From: Paul Cann
Sent: 25 April 2017 16:50
To: Planning.Responses
Subject: RE: Planning Consultation on EP/10/17/DOC

Drainage Engineers comments in respect to conditions 9 & 10;

Site Address: Bradbury Hotel Station Road East Preston BN16 3FF

Description of Works: Application for approval of details reserved by conditions imposed under EP/63/16/PL relating to Conditions 3 - Schedule of materials, 9 - Surface Water Drainage, 10 - SUDS, 13 - Construction Management Plan, 18 - Root Protection Area of adjoining protected Beech Tree.

SURFACE WATER DRAINAGE LAYOUT

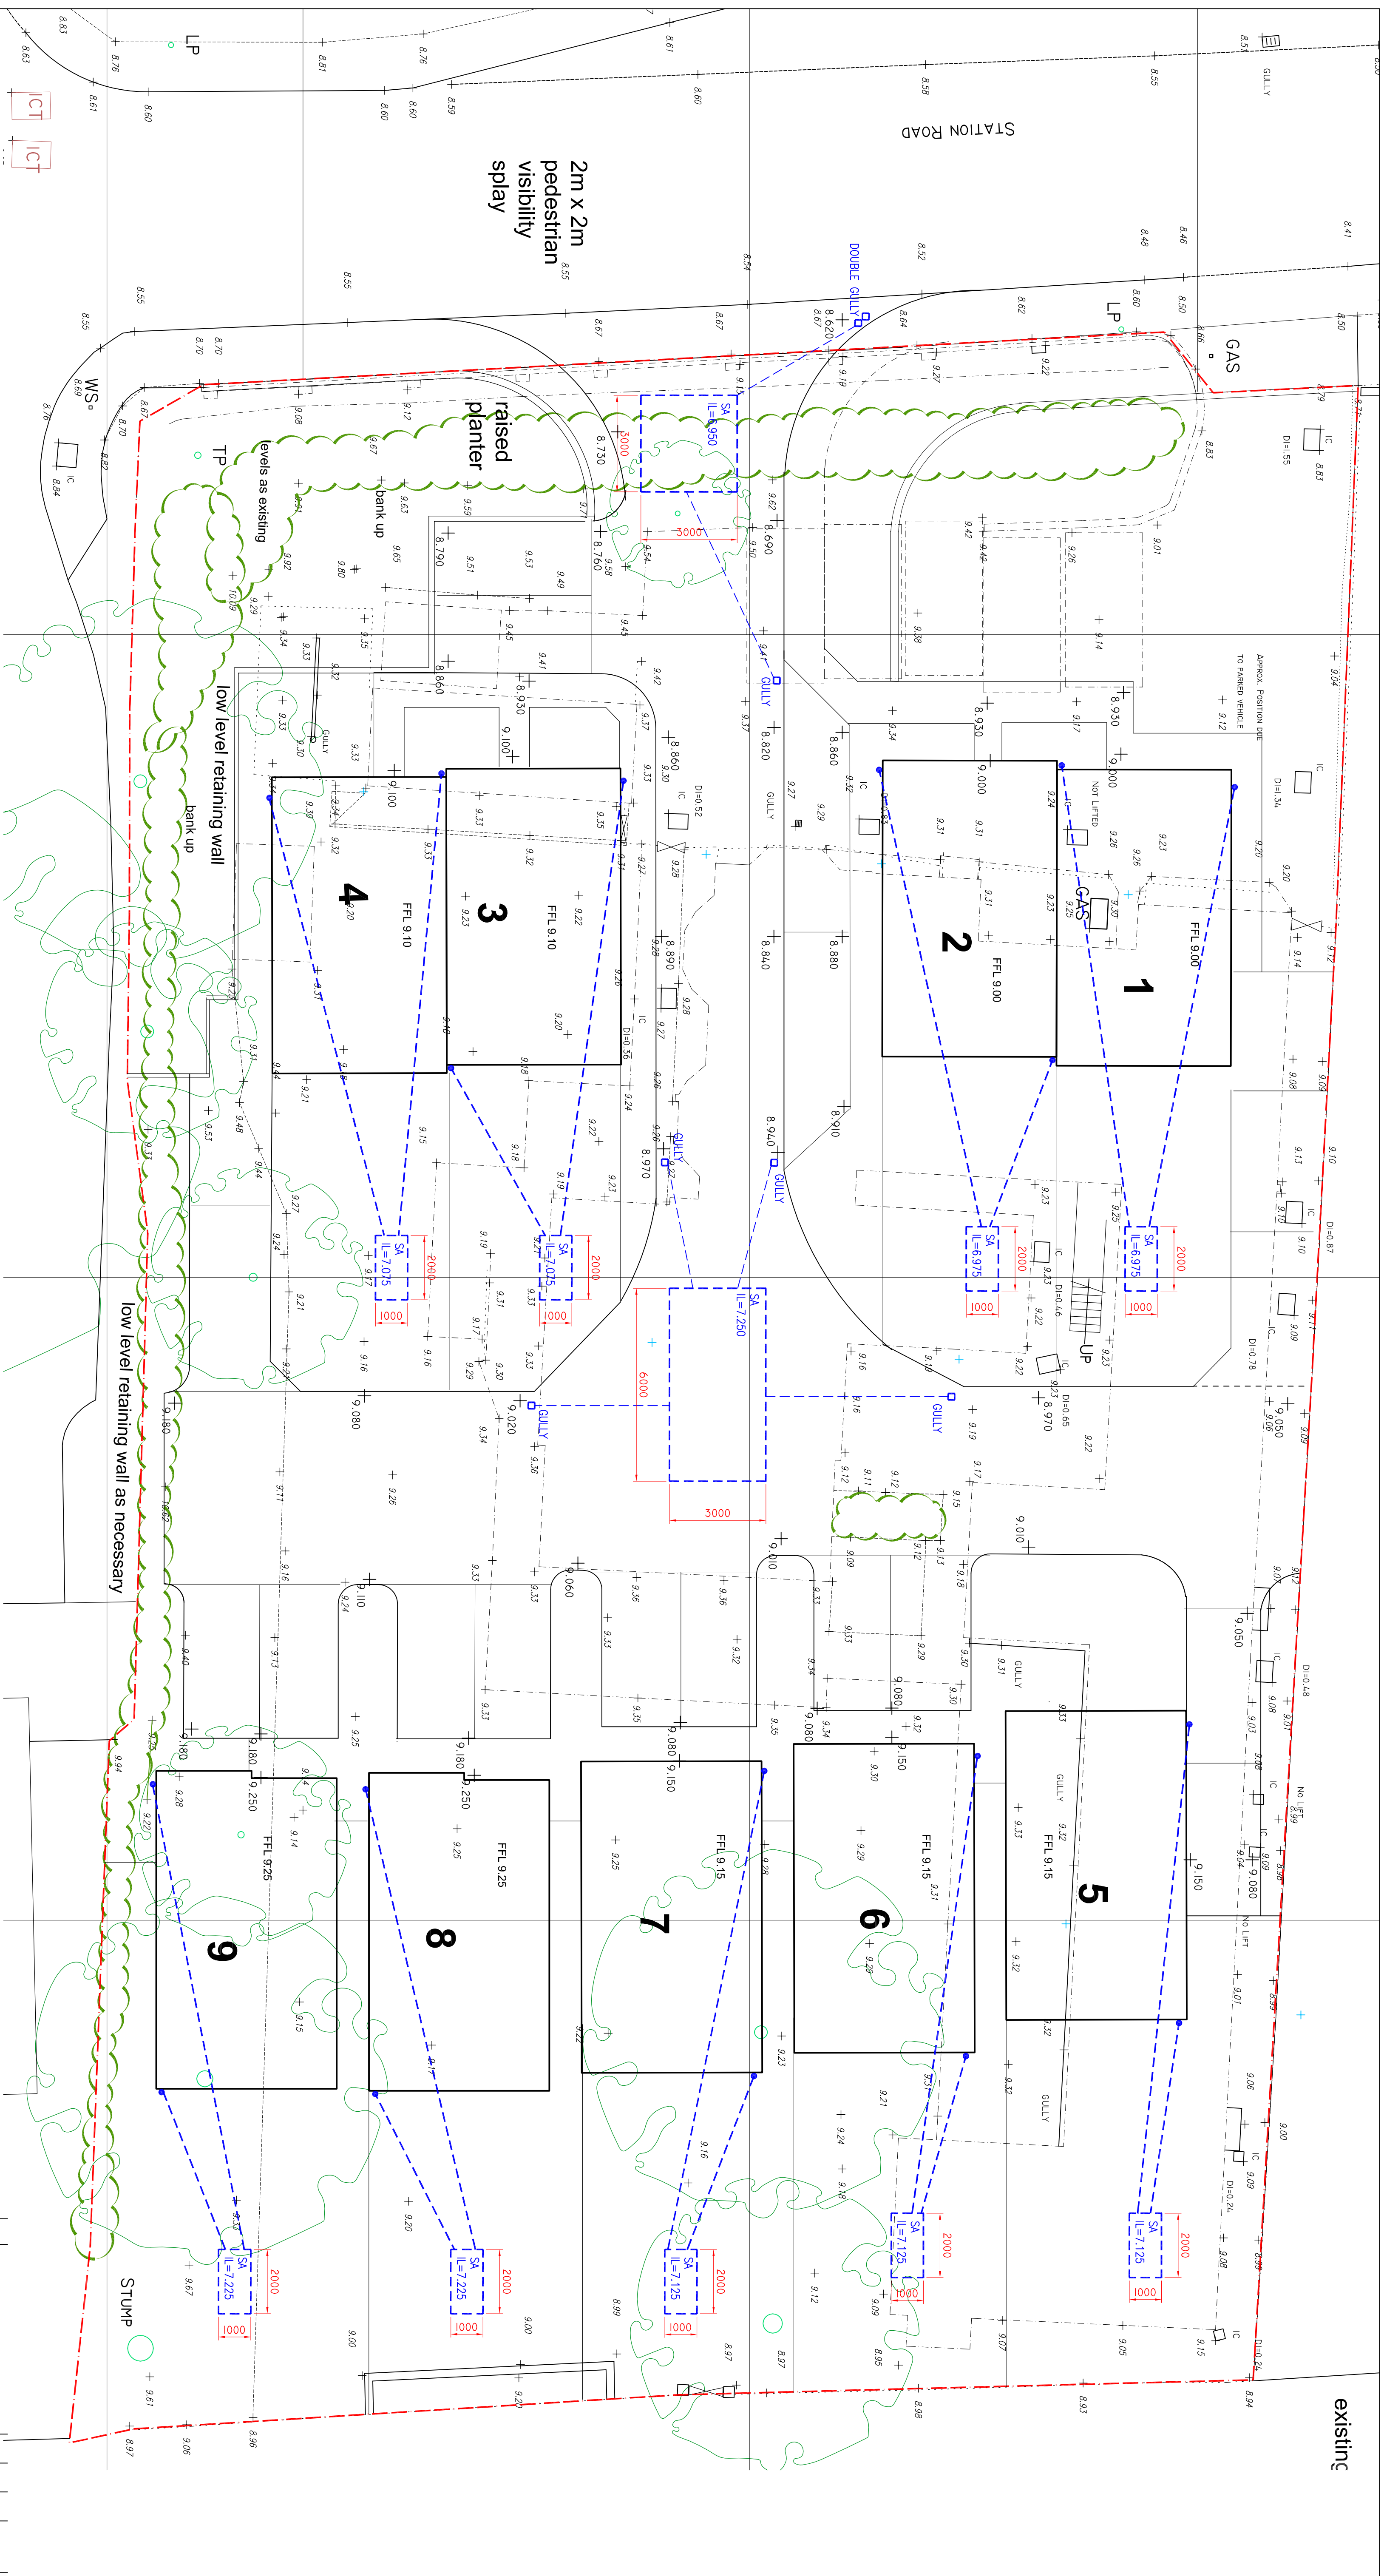
1. No winter groundwater data has been provided. This is critical to the design.
2. Provide the date of when the percolation tests were undertaken, together with a plan showing their locations. Confirm at what depth (ie. water fill level below ground level) each test commenced.

3. Provide a copy of the soils/ground investigation report.
4. The storage calculations provided appear to relate to concrete ring soakaway design, an insufficient design storm event and incorrect impermeable areas. Calculations for the 1 in 10 and 1 in 100 year (+30% Allowance for climate change) are required for each soakaway structure.

5. Why is permeable paving for the highway areas not being considered? This is the preferred method for surface water disposal from the highway areas. The sub base can also be protected from construction traffic, if that is a concern.

6. Additional silt interception is required in the form of catchpit manholes. These are required on all entries to soakaways and also allow a means to clean the upstream pipework.

7. Full constructions details (ie. drawing) of each soakaway structure, gullies and catchpits, etc., are required.
8. Specify pipe gradients/invert levels on all pipes connecting to soakaways.

9. Specify gully outlet invert levels and finished levels for the grated cover. This item may be affected by item 5 of this email.
10. The operation and maintenance manual needs to comply with 'The Suds Manual C753' chapter 32. I also suggest that specific structure type pages in the manual are observed ie. P.467-468 for geocellular tanks.
